From: Zac Denton
Sent: 25 July 2019 09:34
To: Planning Scanning
Subject: FW: Mistletoe Farm, Horsemere Green Lane. CM/13/19/RES; Revised Drainage Proposals

om: kazys <[REDACTED]>
Sent: 17 July 2019 09:54
To: Laura Gibbons <[REDACTED]>
Cc: Edward Rees <[REDACTED]>; Zac Denton <[REDACTED]>
Subject: Mistletoe Farm, Horsemere Green Lane. CM/13/19/RES; Revised Drainage Proposals

Drawing Title Engineering Details Drainage Strategy (with Ditch)				
Drawn KN	Checked	Scales 1:250	Paper Size A1	Date 07.19
Job No. ES1820	Drawing No. 602-04	Revision B

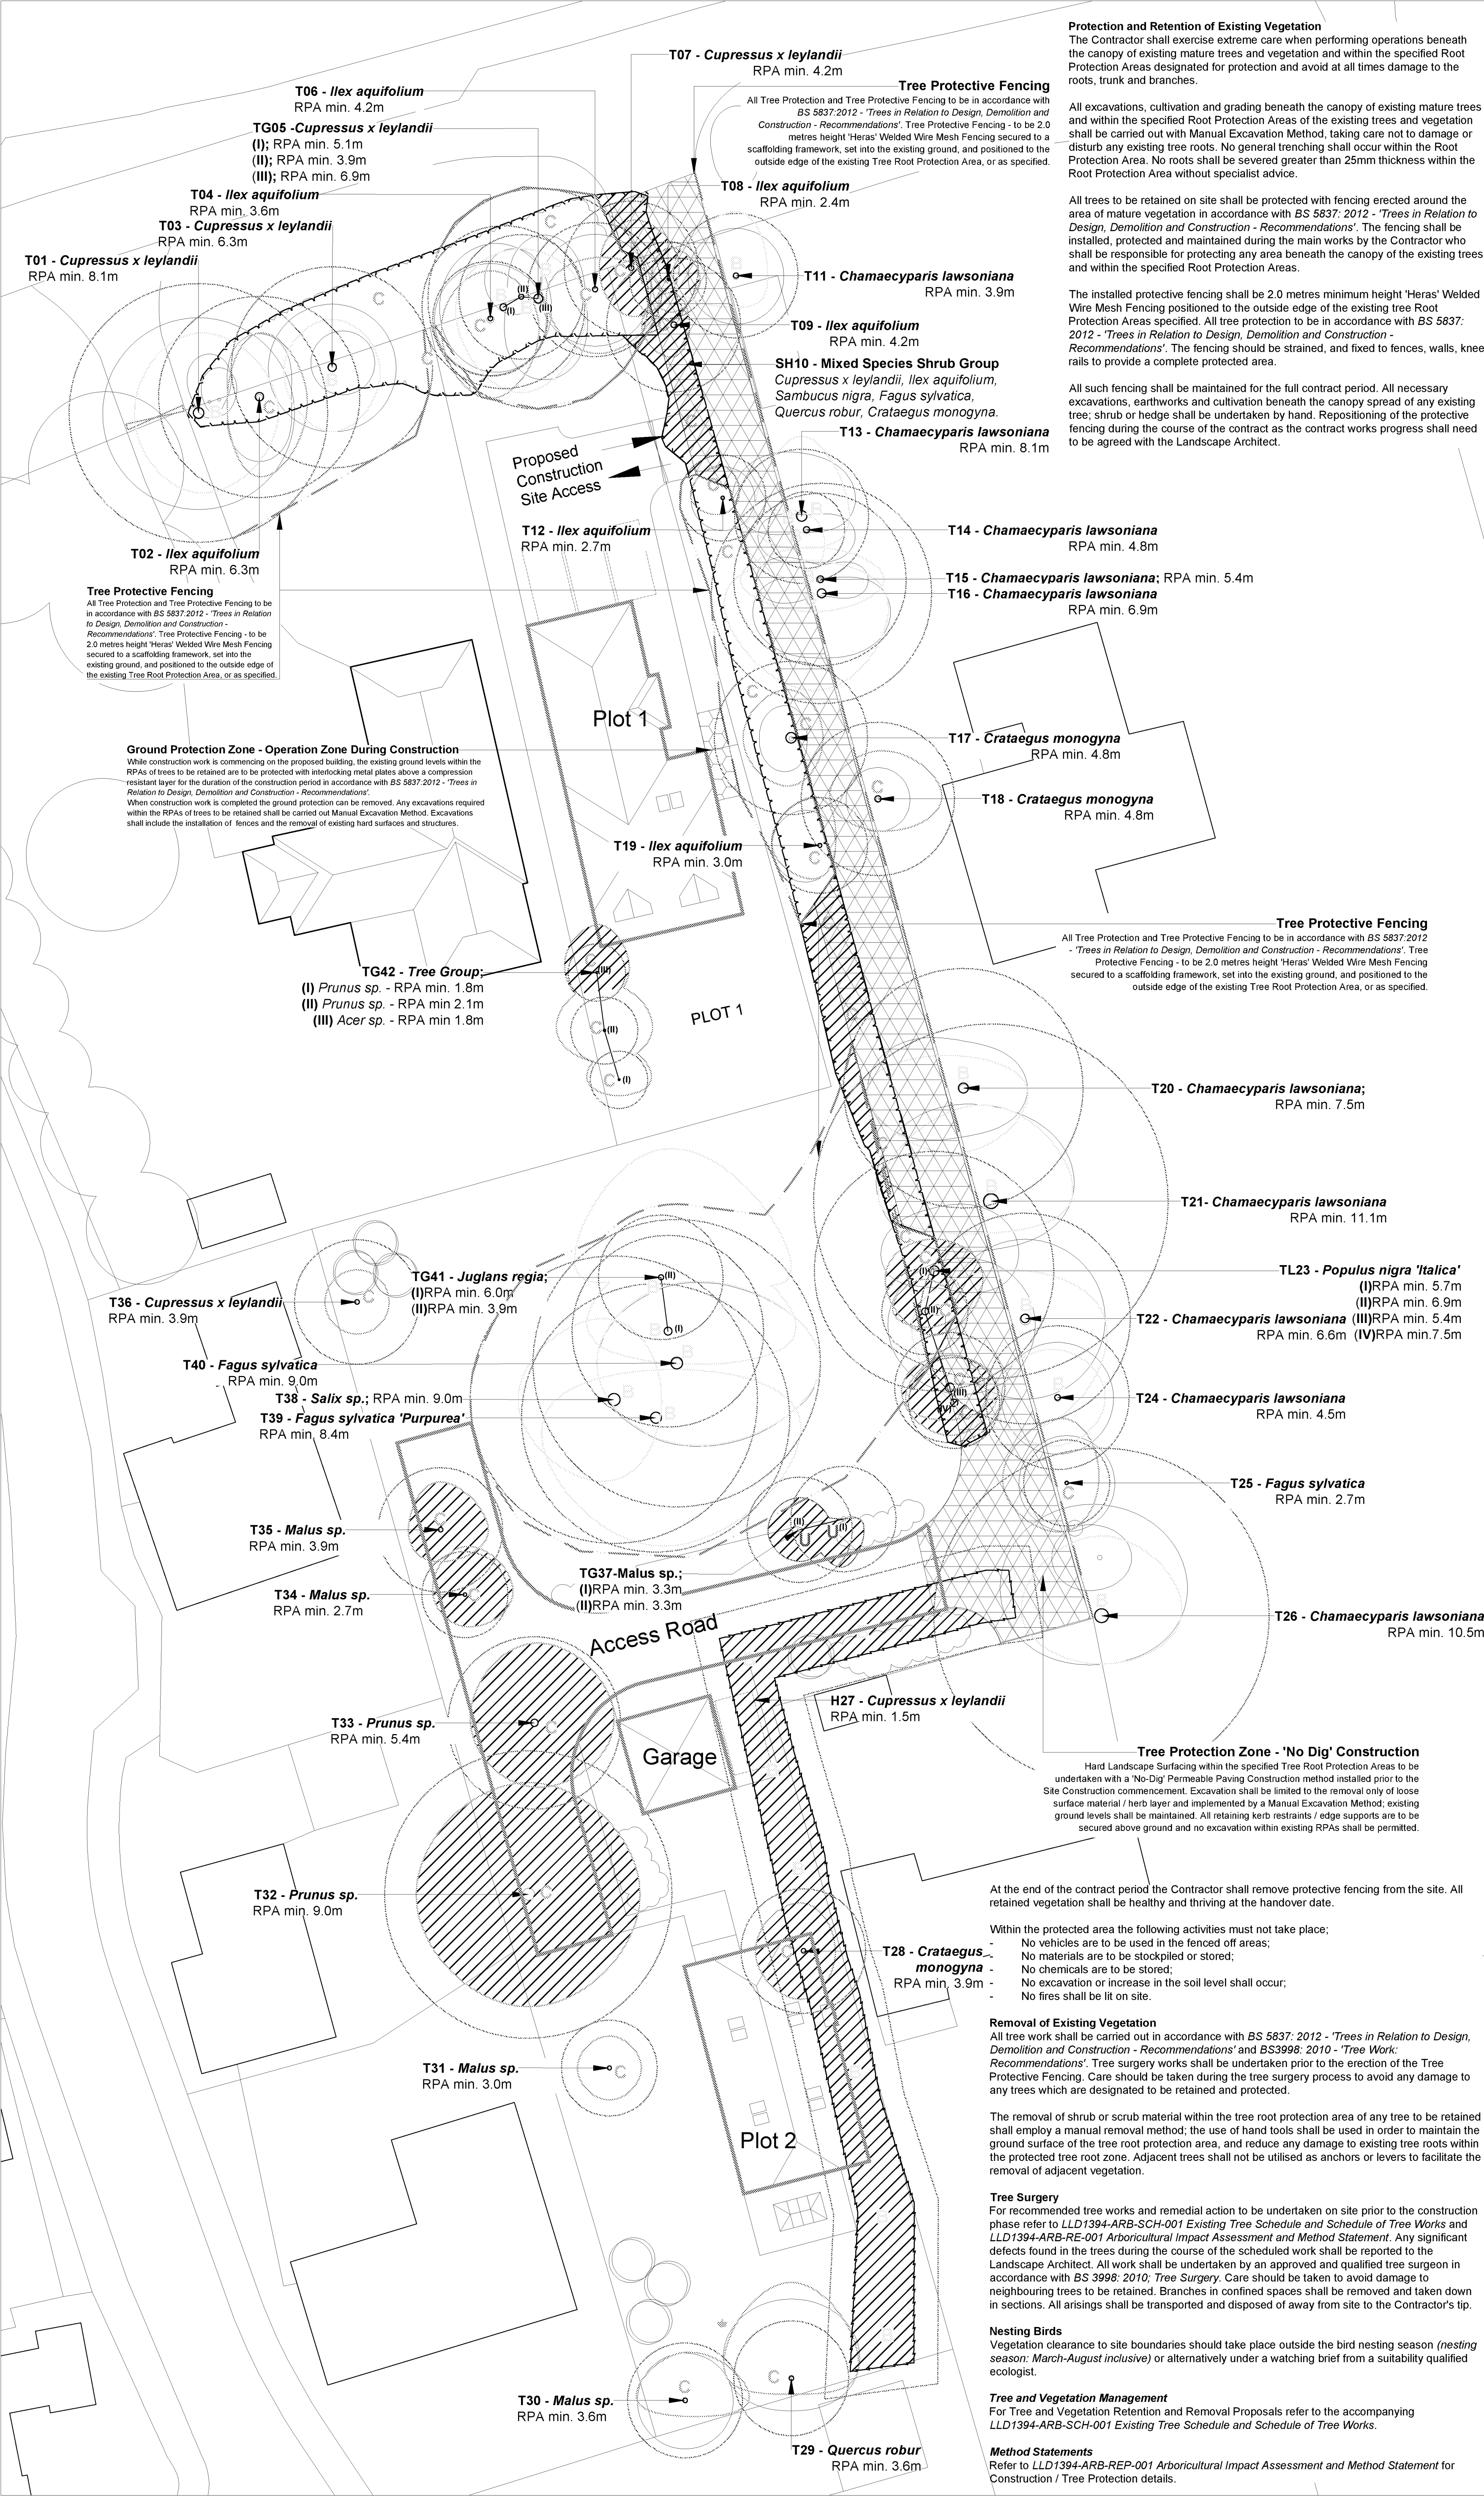
Please consider using permeable paving in the two areas that you can (proposed access road T and parking area for plot 1) with these areas providing storage. Pipework connections will of course be required, but we are hopeful that this may shallow the drainage solution and remove the pump requirement.

If you can label up the drawings with pipe diameters and falls that would be useful.

In brief I have provided permeable surfacing at the junction of Roads 1 & 2 and in the parking area of plot 1. These have been linked with a piped system and I've managed to incorporate a ditch/swale in the network. Final gravity discharge into the adjacent watercourse will be restricted to 2.0 lits/sec but in practise I anticipate it will be at a rate lower than this. The final design and modelling will be dependant on undertaking infiltration testing in the winter and if you require we can undertake groundwater monitoring through the winter period for the shallow soakaways.

Drawing Title				
Engineering Details Drainage Strategy (with Ditch)				
Drawn	Checked	Scales	Paper Size	Date
KN		1:250	A1	07.19
Job No.	Drawing No.	Revision		
ES1820	602-04	C

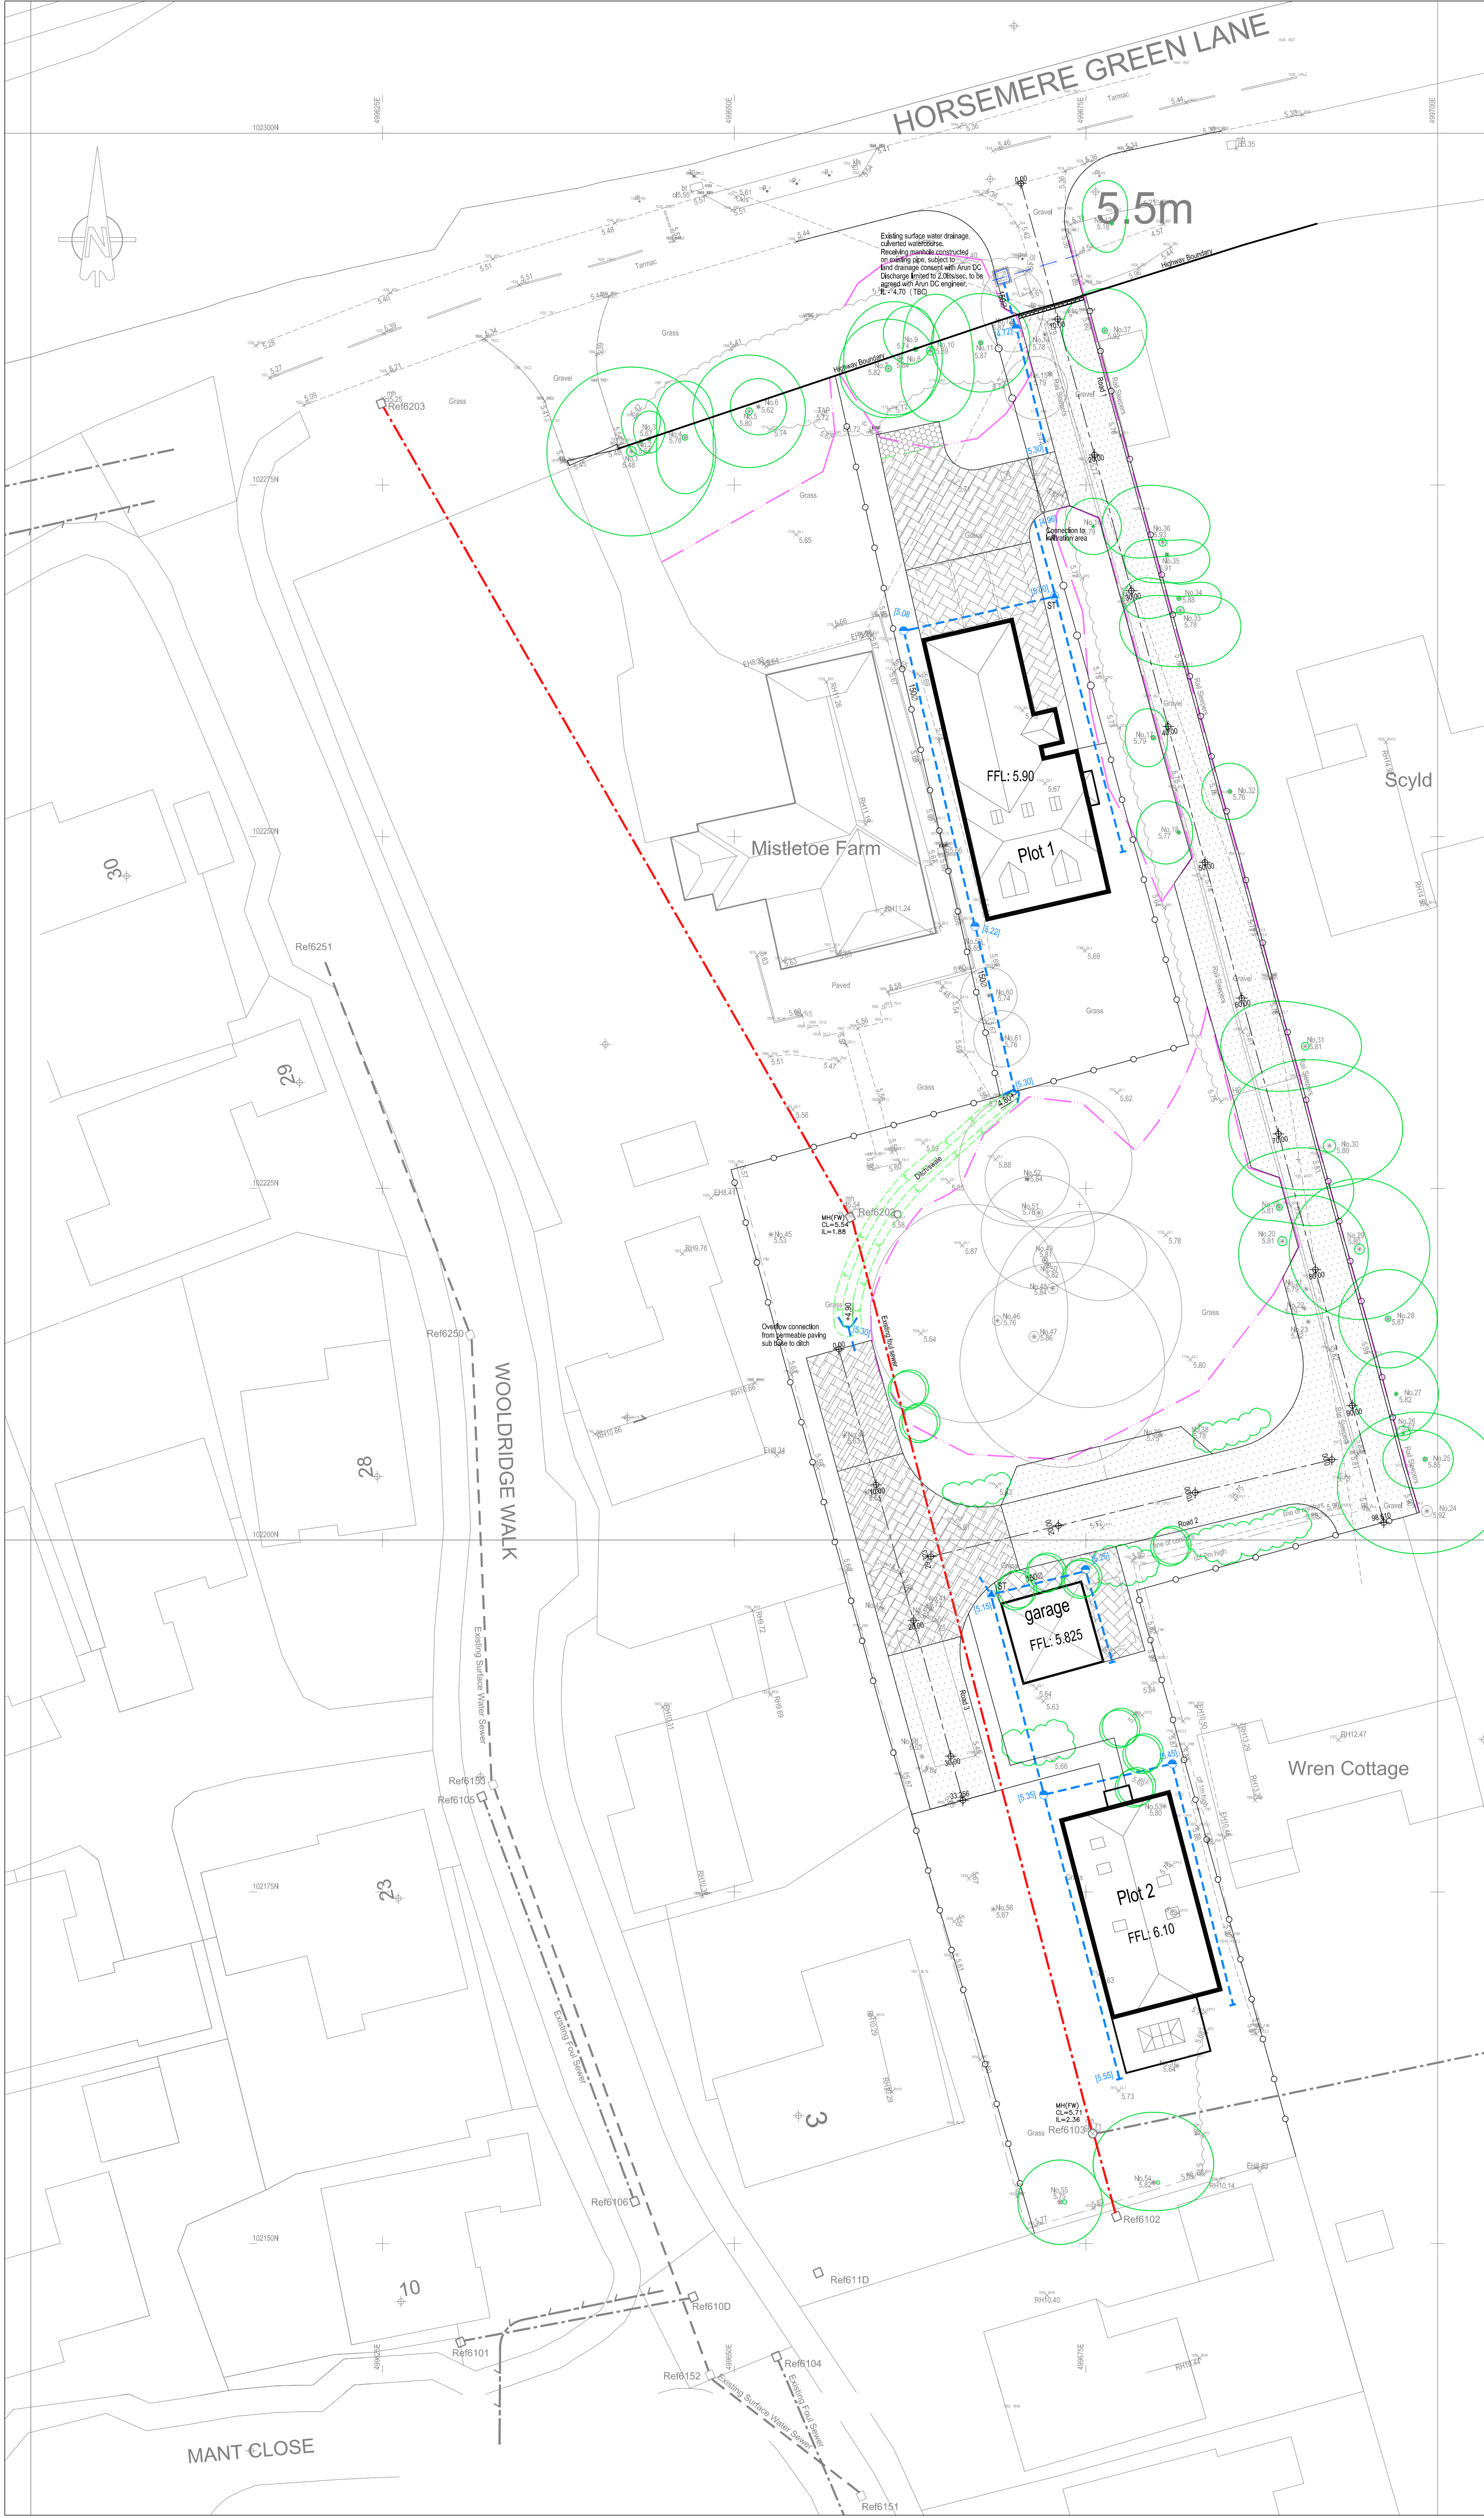
Thank you for sending over the revised plan. I believe there is some conflict between what you are proposing and the tree protection plan (attached).

The permeable paving for plot 2 looks like it could only be located in the T furthest round on the road rather than at the junction of roads 1 and 2. The swale also appears to be within a no dig area.

Thank you for your comments. I was under a misapprehension regarding the RPZ so having cleared that I have put together a revised proposal which addresses your comments on the RPZ. Hopefully you find this revised proposal accords with your thoughts and you are able to advise
